STATE OF NORTH CAROLINA  
DEPARTMENT OF TRANSPORTATION

**Addendum No. 1**

RE: Contract ID C203008

Bridge #30 On US-421 Over Snow's Cut (Intracoastal Waterway)

EXPANSION JOINT REPLACEMENT DETAILS (BENTS 1-9, 14-26)

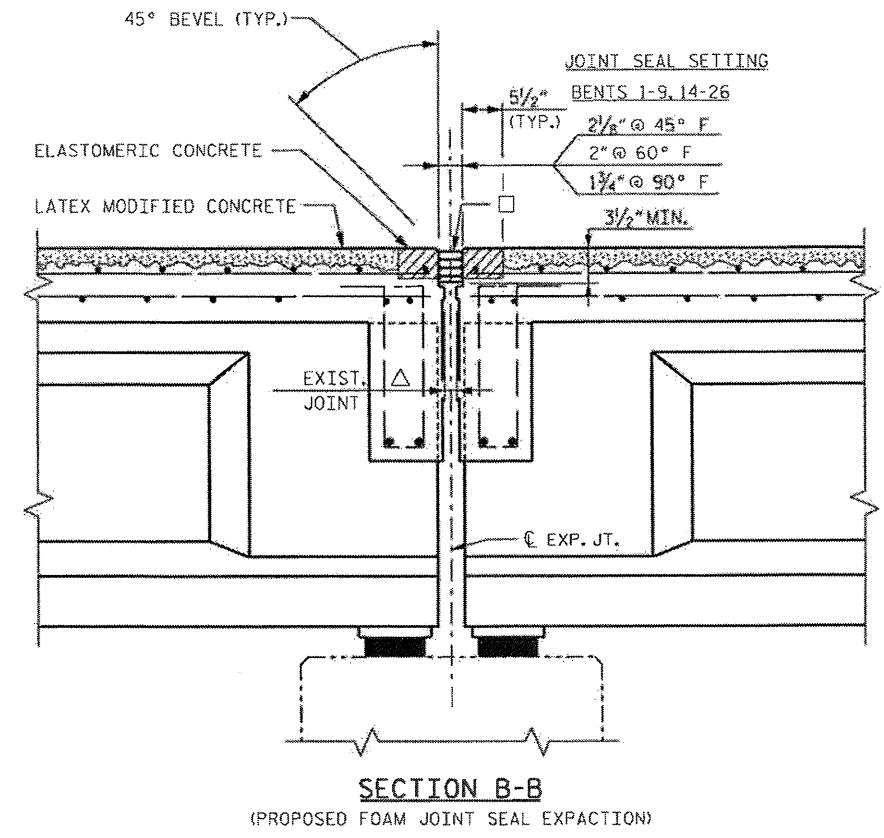
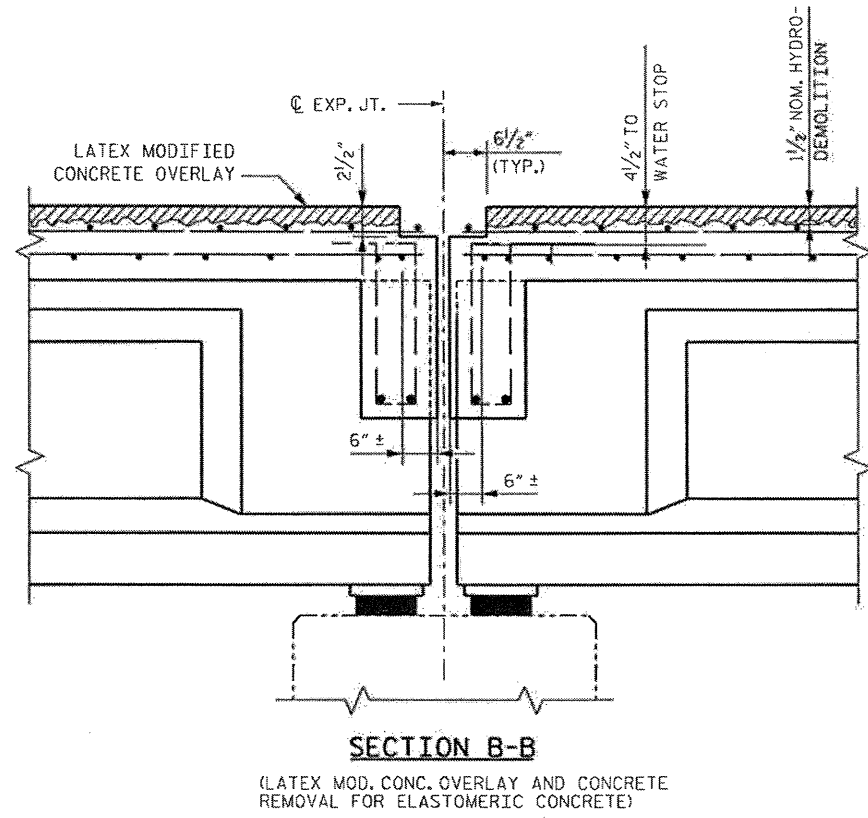
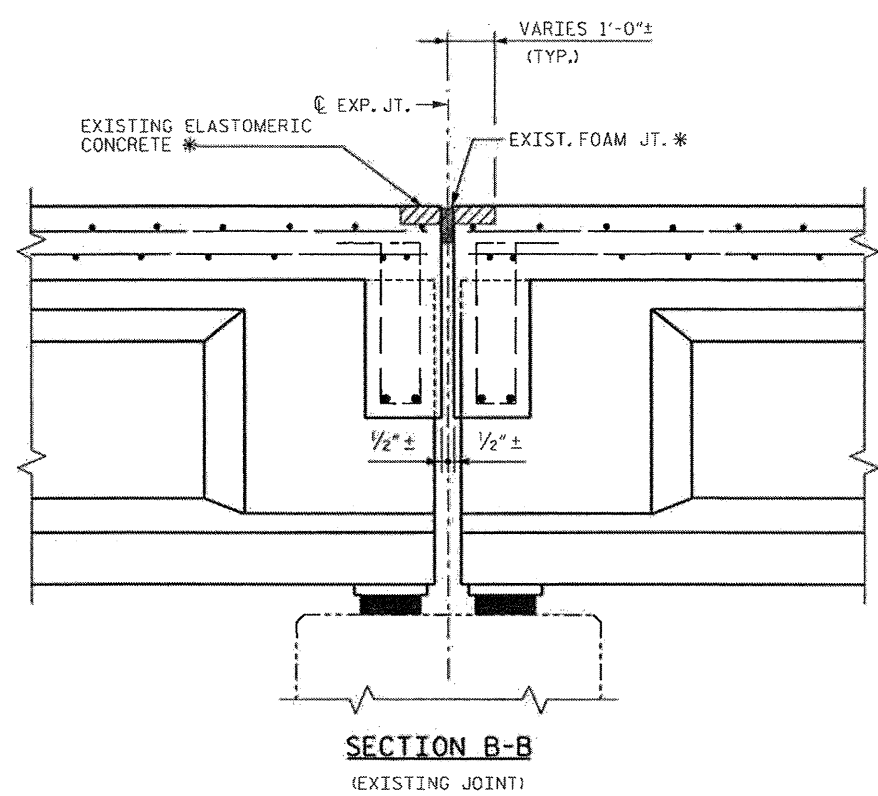
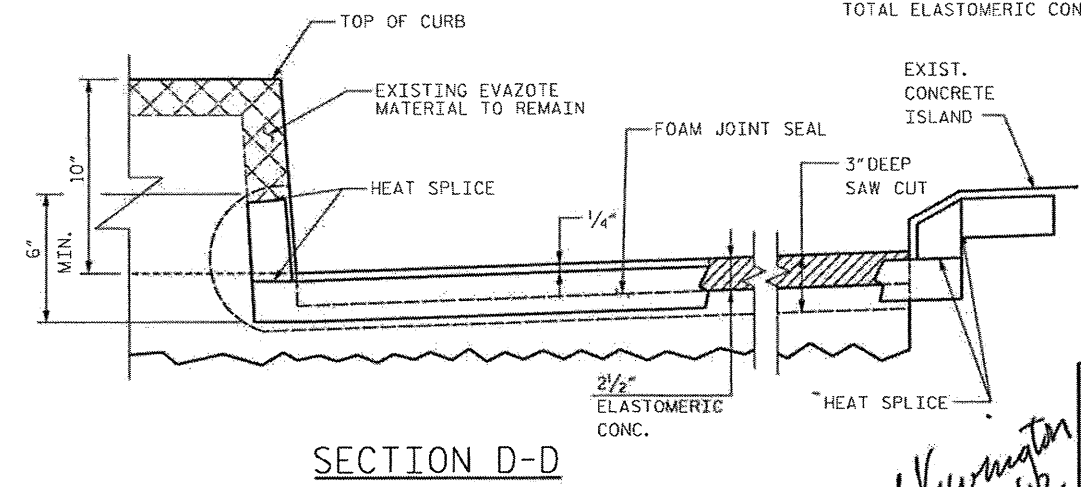
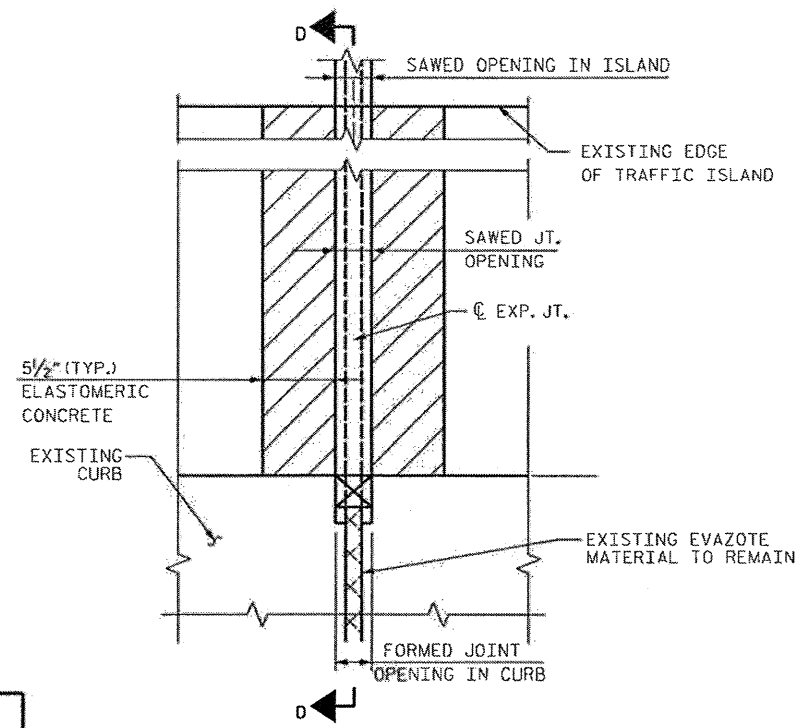
Sheet No. S-23 has been revised to require elastomeric headers at all joints and to show details for the correct joint construction. Please void Sheet No. S-23 in your plans and staple the revised Sheet No. S-23 thereto.

STATE OF NORTH CAROLINA
 DEPARTMENT OF TRANSPORTATION
 RALEIGH
 SUPERSTRUCTURE JOINT AND SLAB REPAIR DETAIL 3

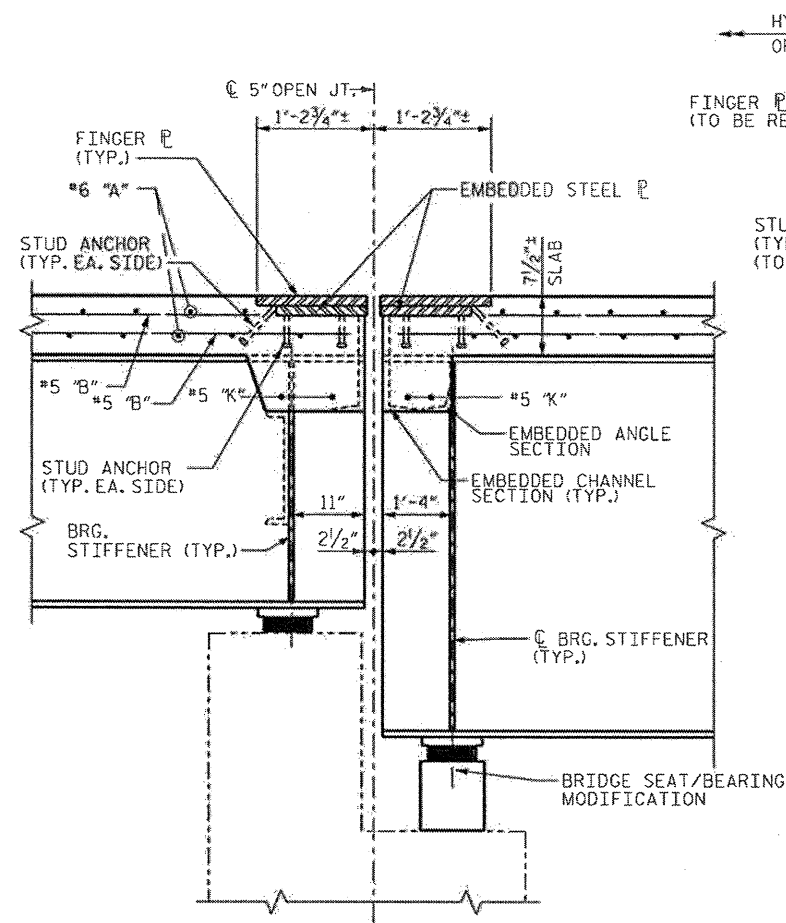
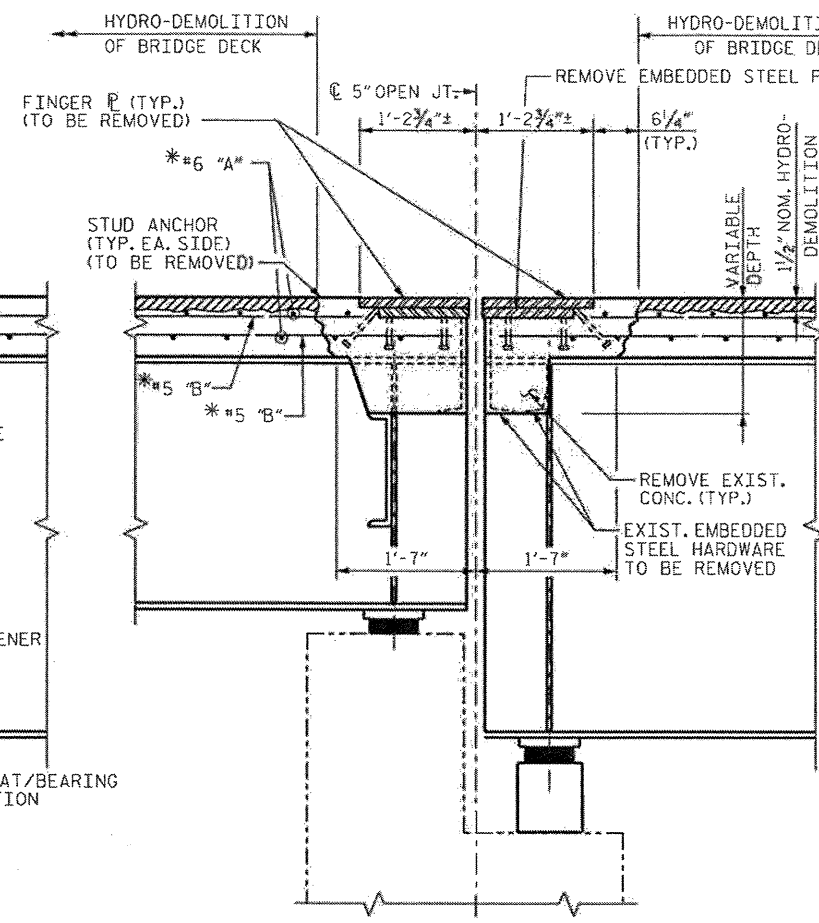
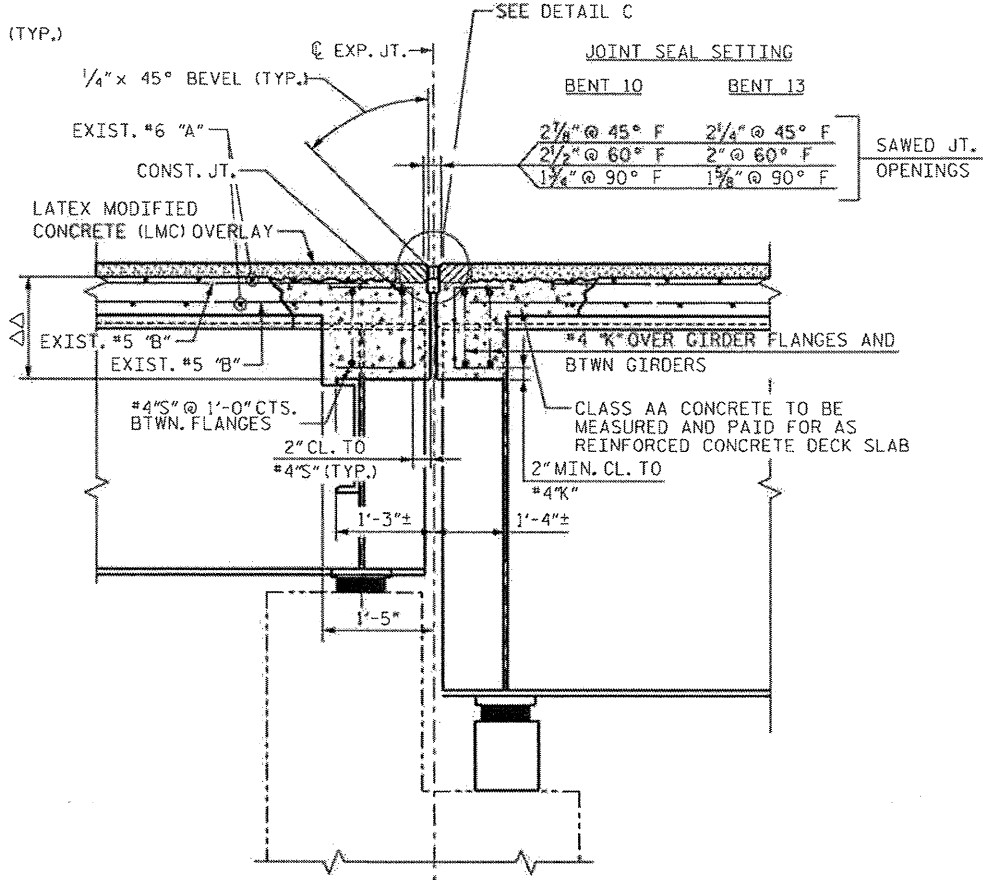
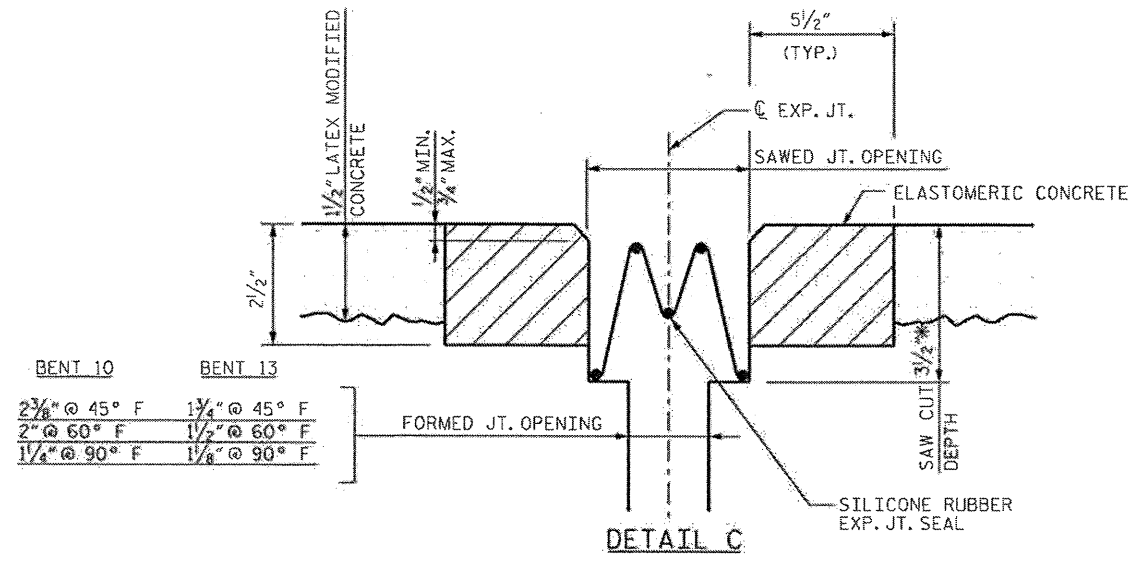
Sheet Nos. S-26 and S-27 have been revised to require elastomeric concrete at all joints. Please void Sheet Nos. S-26 and S-27 in your plans and staple the revised Sheet Nos. S-26 and S-27 thereto.
